From: Bloomer, David <David.Bloomer@lancashire.gov.uk>
Sent: 07 April 2016 14:41
To: Robert Major
Cc: LHS Customer Service; planning
Subject: app3/2016/0247 89 King Street Whalley

Dave Bloomer
Highways Development Control
Lancashire County Council

PROPOSED GROUND FLOOR PLAN

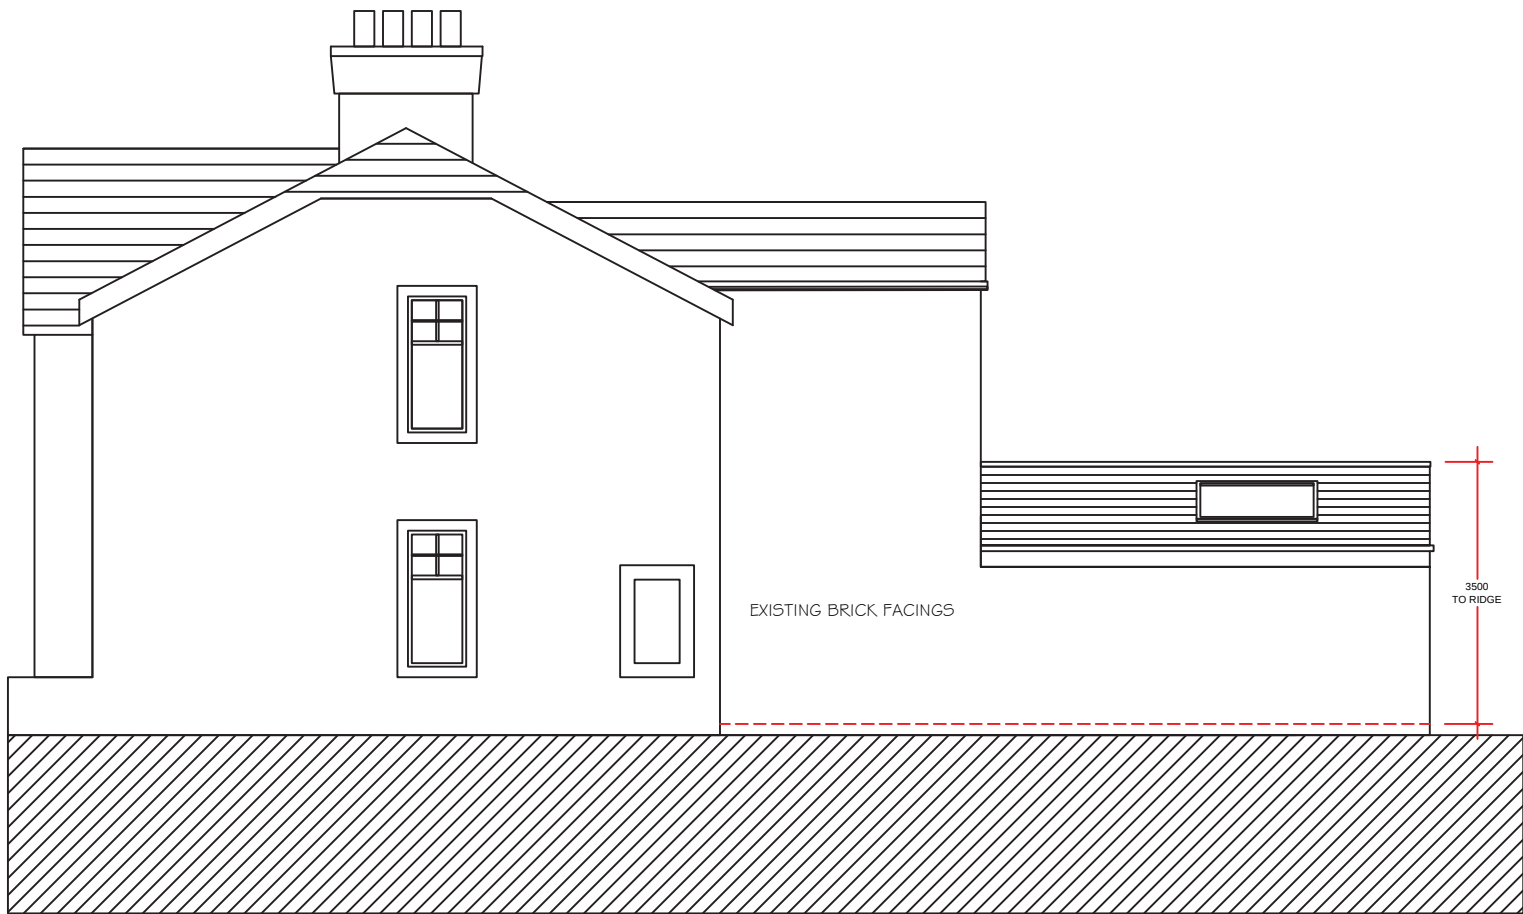
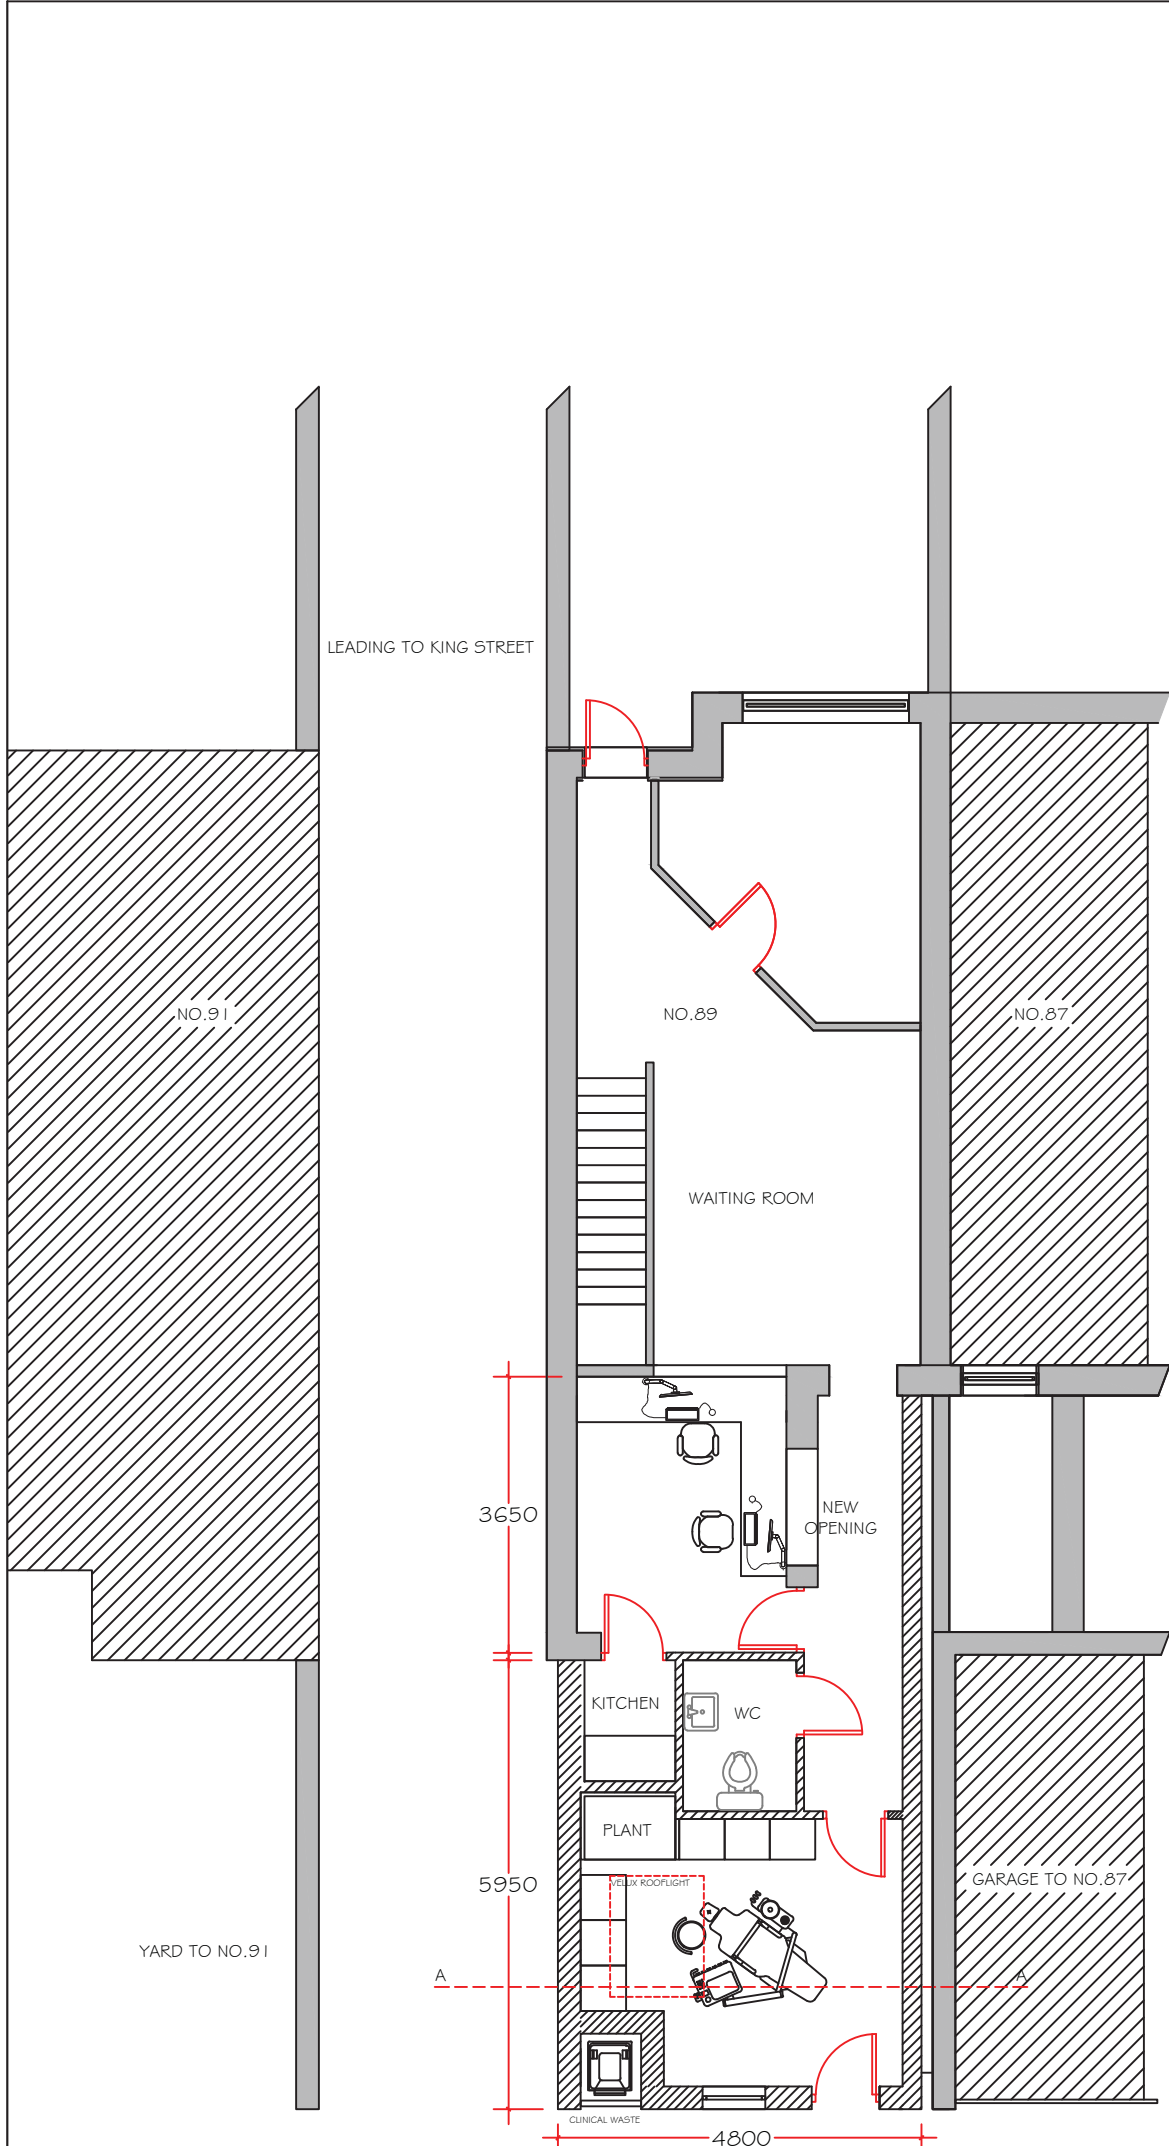
The proposed extension will take up the whole of the property's rear yard . Currently this area is used for parking contrary to Q10 of the application form which states that the existing parking is zero. Also there are no facilities for waste storage (domestic and recyclables) and the only provision is for clinical waste which requires the access door to open out over the highway. The applicant has not shown any floor layout for the first floor so it is unclear whether this is used as part of the dental practice or a residential flat

On the basis of the application as submitted I would have to recommend that he application be refused on the grounds that the proposal will have a detrimental effect on the town centre parking provision leading to greater competition for on street parking spaces to the detriment of local residents and businesses. Also the lack of adequate and acceptable waste storage facilities would result in the potential for waste to be stored on the adjacent highway.
